From: [REDACTED]
Sent: 03 January 2024 22:30
To: Planning
Subject: Comment on planning application 3/2023/0926

Application number 3/2023/0926

Location address: 2 Water Meadows, Longridge, PR3 3BW

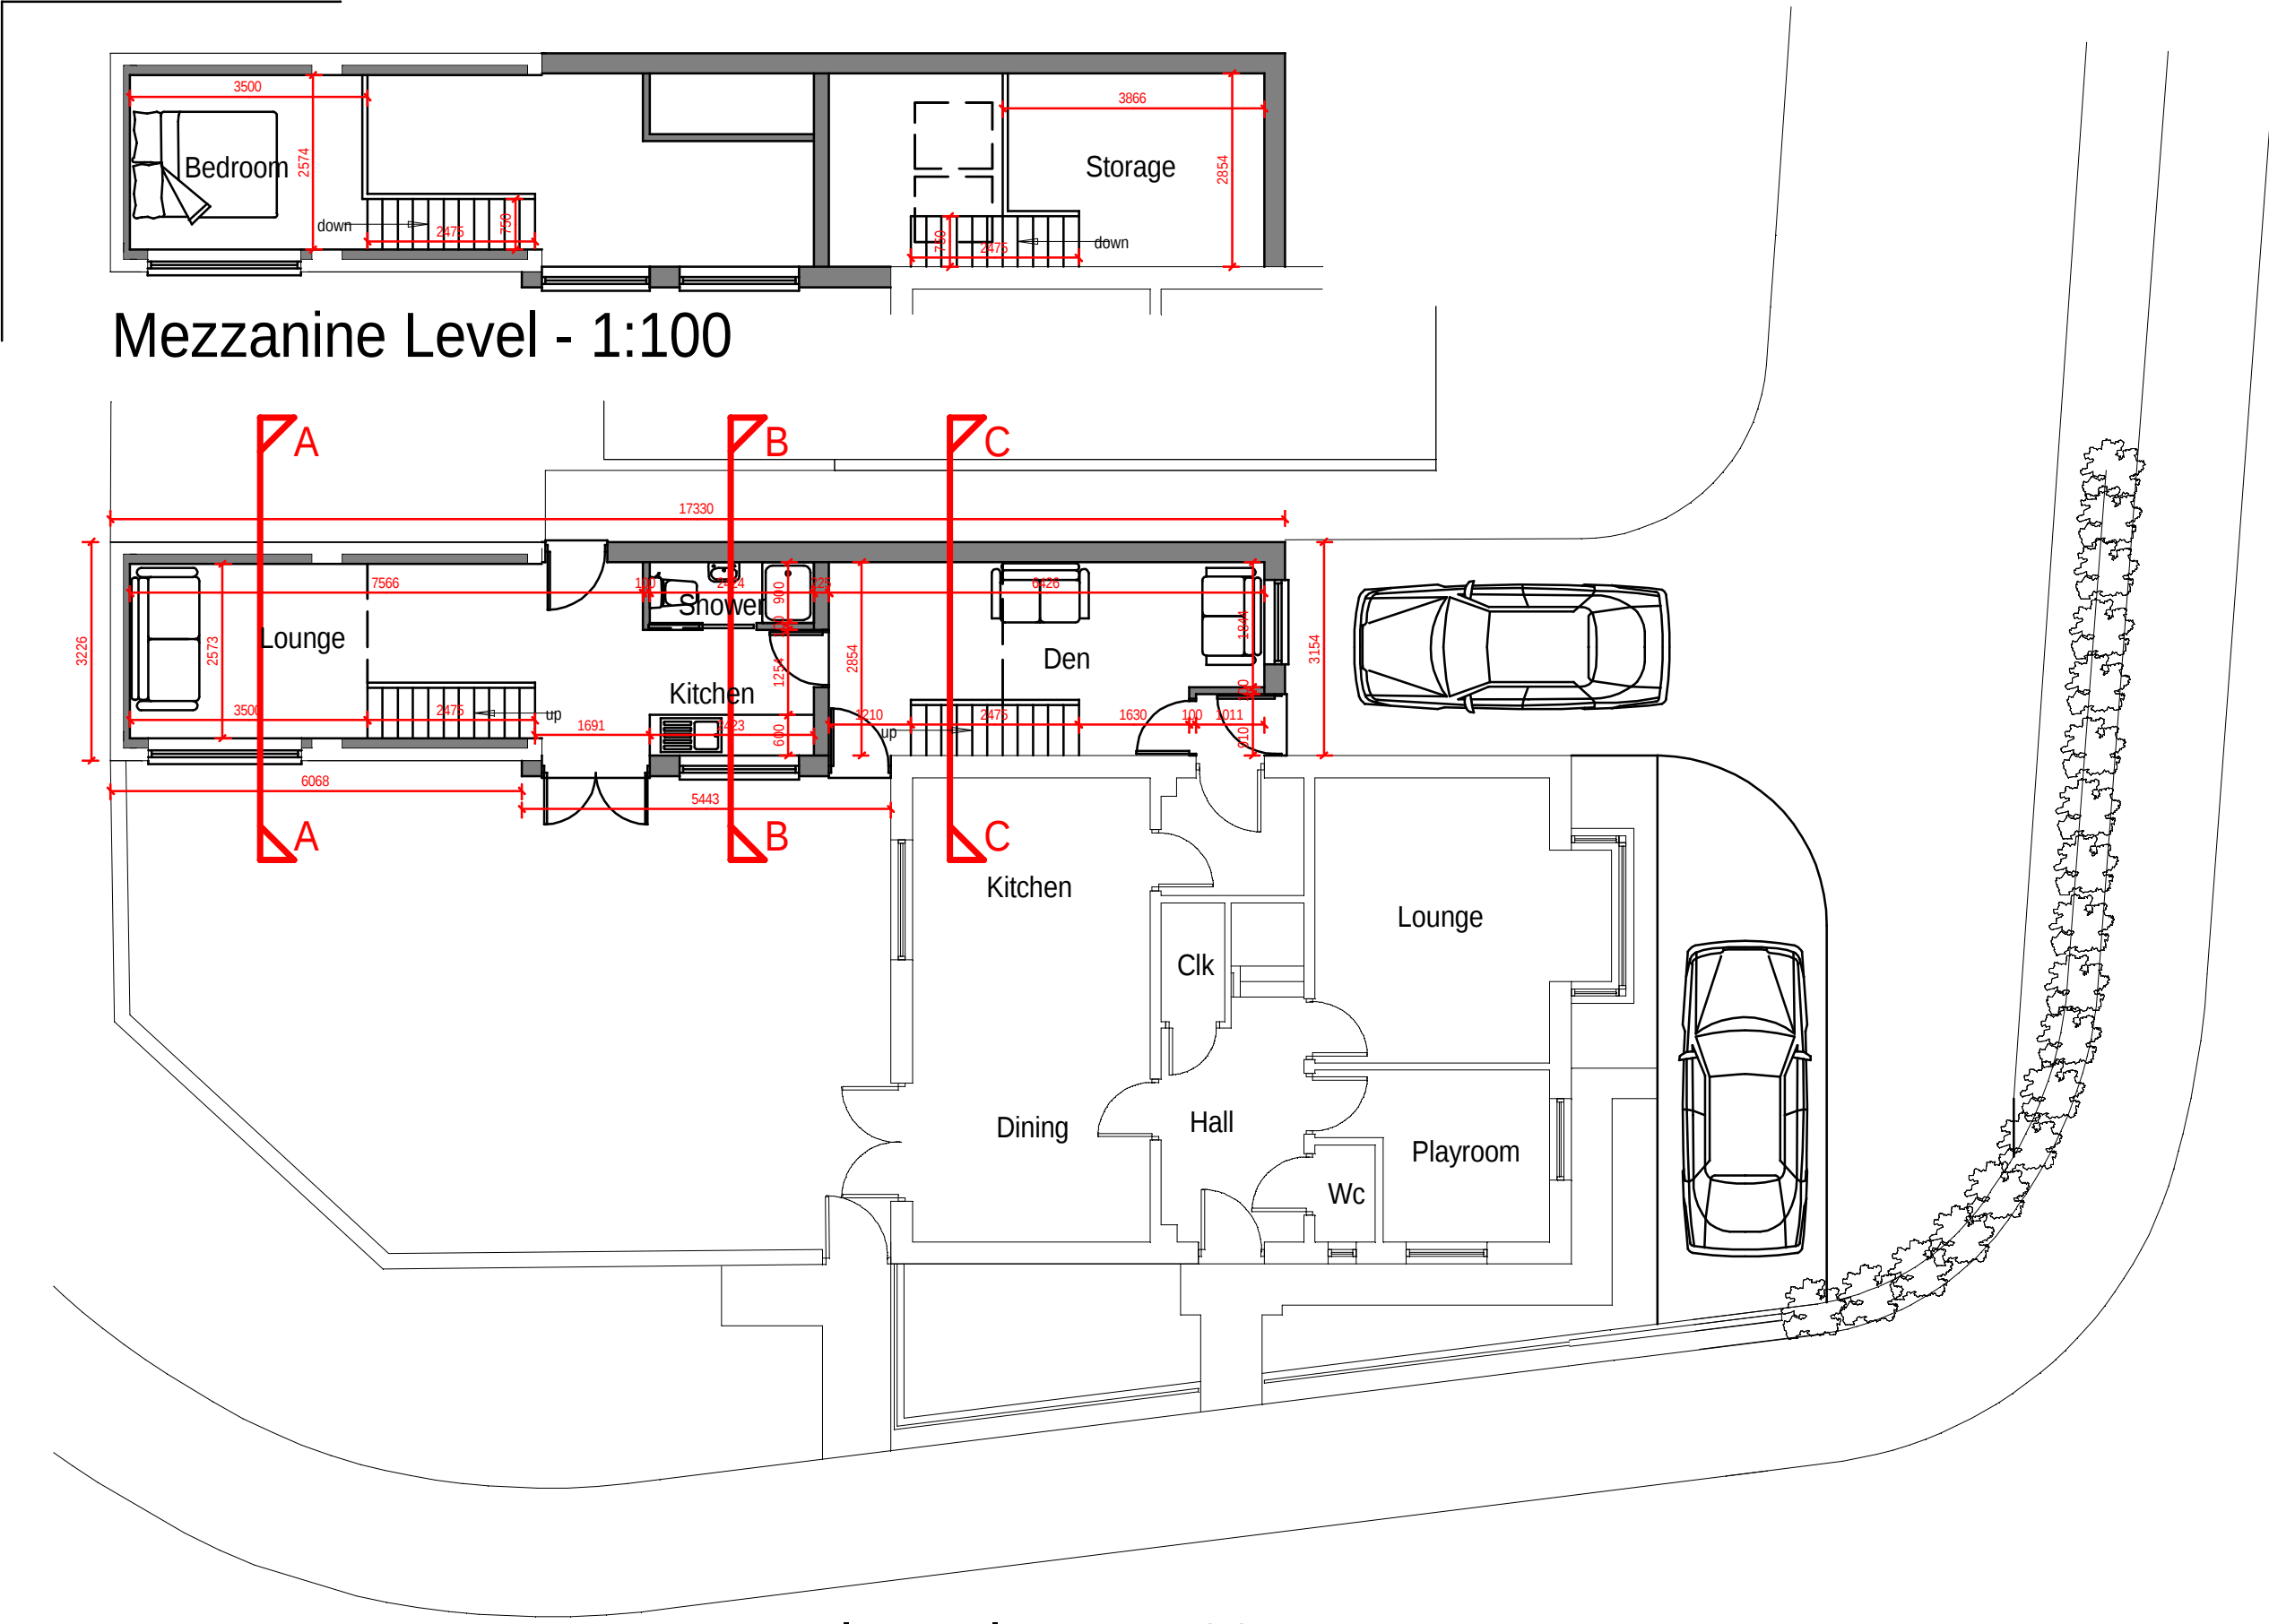
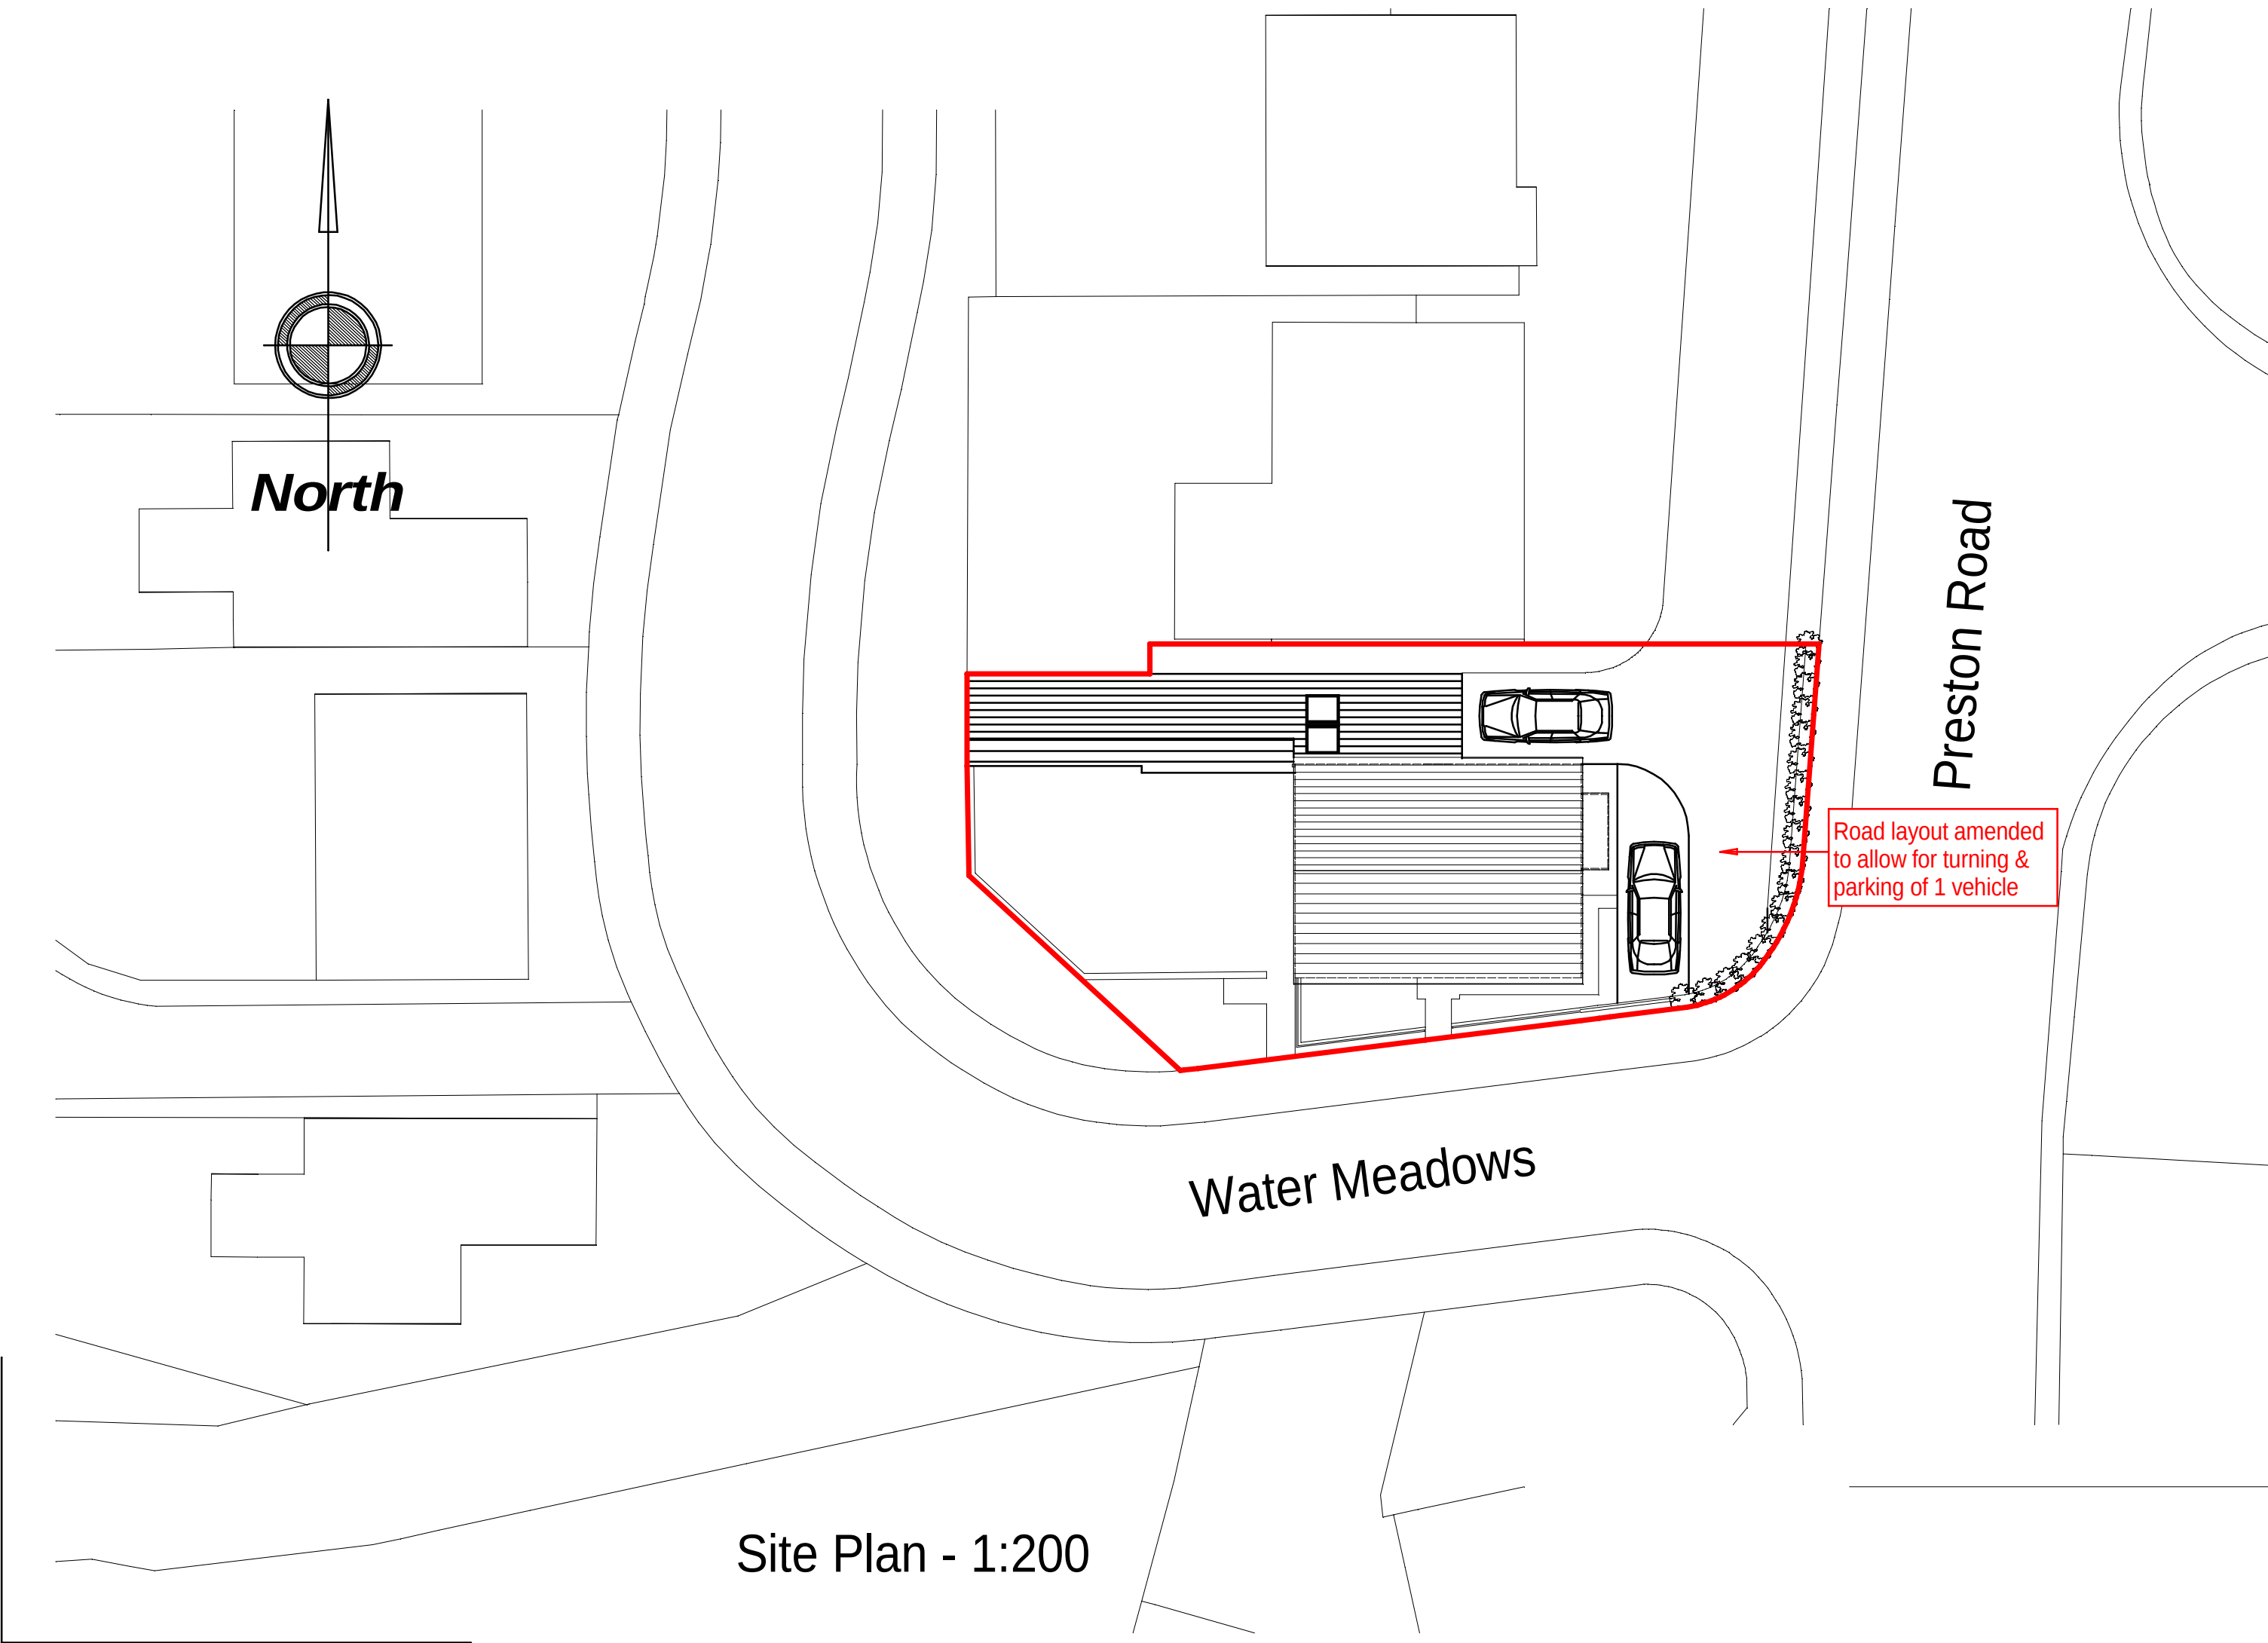
1. The applicant states that whilst the garage will be converted, the car parking spaces will remain. This is incorrect. The property can currently accommodate 2 or 3 cars on the driveway in front of the garage without utilising the area allocated as a turning circle for all properties, visitors and delivery vehicles on the shared access. As previously stated, building on part of the driveway will displace vehicles to park on the turning circle. We don't believe there is sufficient space to park two vehicles in the turning circle and allow room for turning.

2. The applicant states that it is applying for permission to build a 1 storey extension. This is incorrect. The plans show a 2-storey extension including using the shell of the current separate garage and an increase in height, joining the garage when converted to the main house. There is a mezzanine bedroom and a storage area on the second floor, accessed by separate staircases.

3. The proposed extension would result in the size of the property increasing by approximately 60%. The current building has a total area of approximately 128 sq. metres. The proposed extension would add an additional 75 sq. metres resulting in a 2-storey building with over 200 square metres of space.

4. Whilst described as an extension, the proposals actually amount to a separate 1-bedroom dwelling (if not 2 or 3), akin to a mill style duplex conversion; with separate washing and kitchen facilities, its own lounge and den, and a parking space. It also has its own separate access via the path between the extension and the neighbouring property. There is also scope for the den and living room to be second and third bedrooms. Whilst we do not know the intentions of the current owner, the extension would be a desirable location to rent as an Airbnb in the future, given the locality and local countryside walks etc.
